From: Simon Davis
Sent: 04 July 2019 17:10
To: Trish Paul [REDACTED]
Cc: [REDACTED]
Subject: RE: BR/129/19/PL 75 Highfield Road

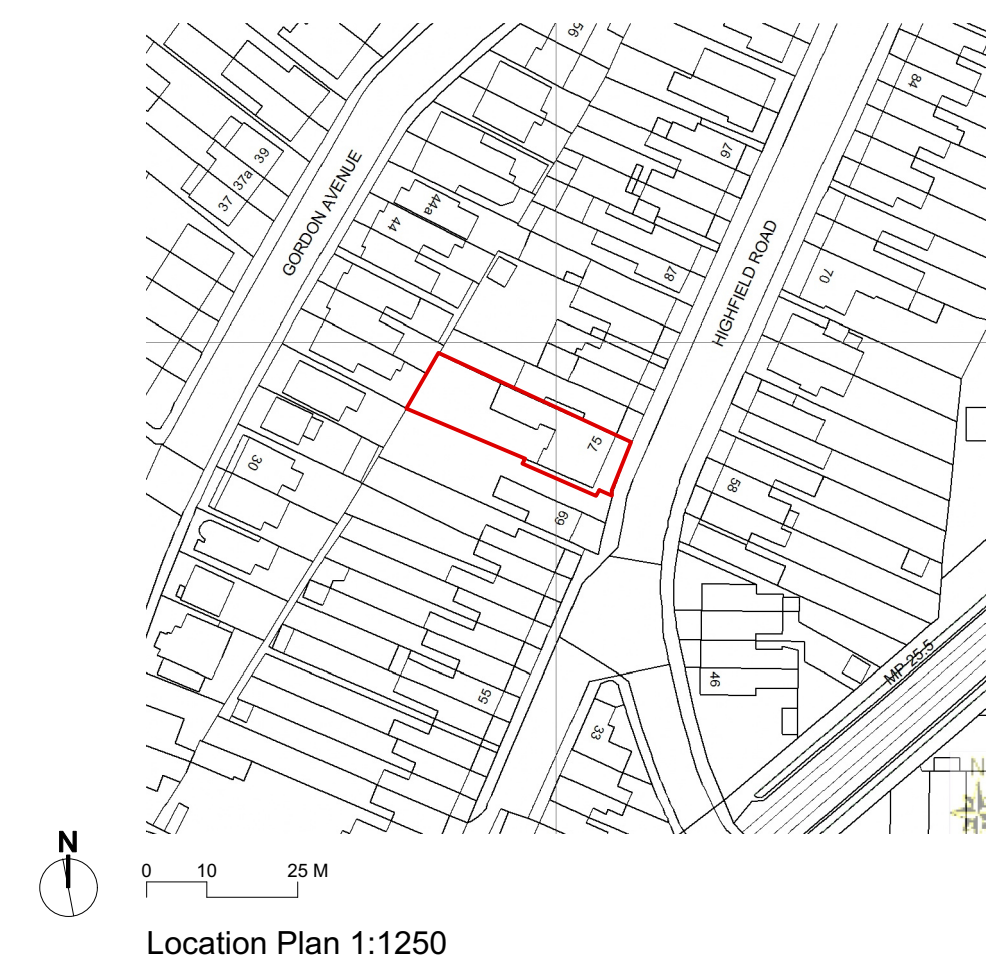
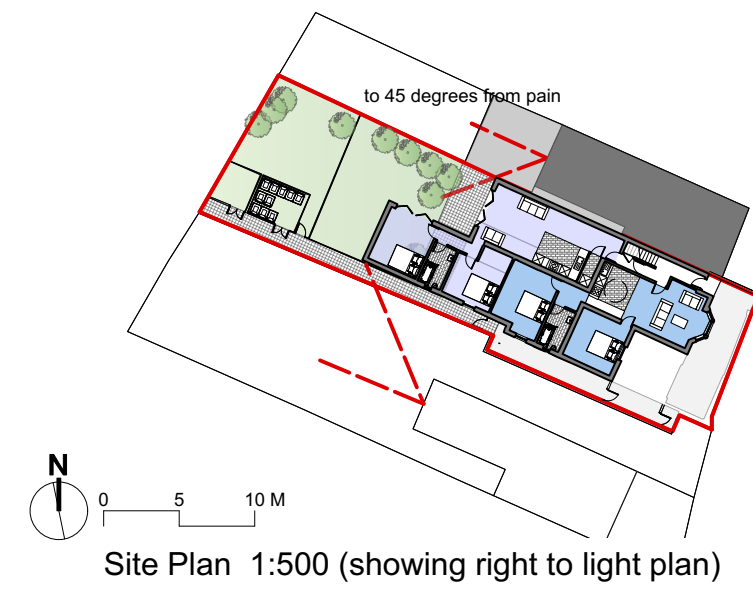
Regarding the plan provided by Nick, it refers to a section of wall to be removed but the arrow points to a wall that according to my photos, is not there. Could this be fixed please. I have outlined what I believe to be the correct bit of wall in blue on the attached. Also, we will need a tracking diagram to show how a car can manoeuvre into the 2nd parking space (following relocation/removal of the pole and removal of the wall). If it is necessary for a vehicle to go across the area I have shaded yellow then I consider that you will need to provide a new ownership certificate and serve notice on the adjacent landowner.
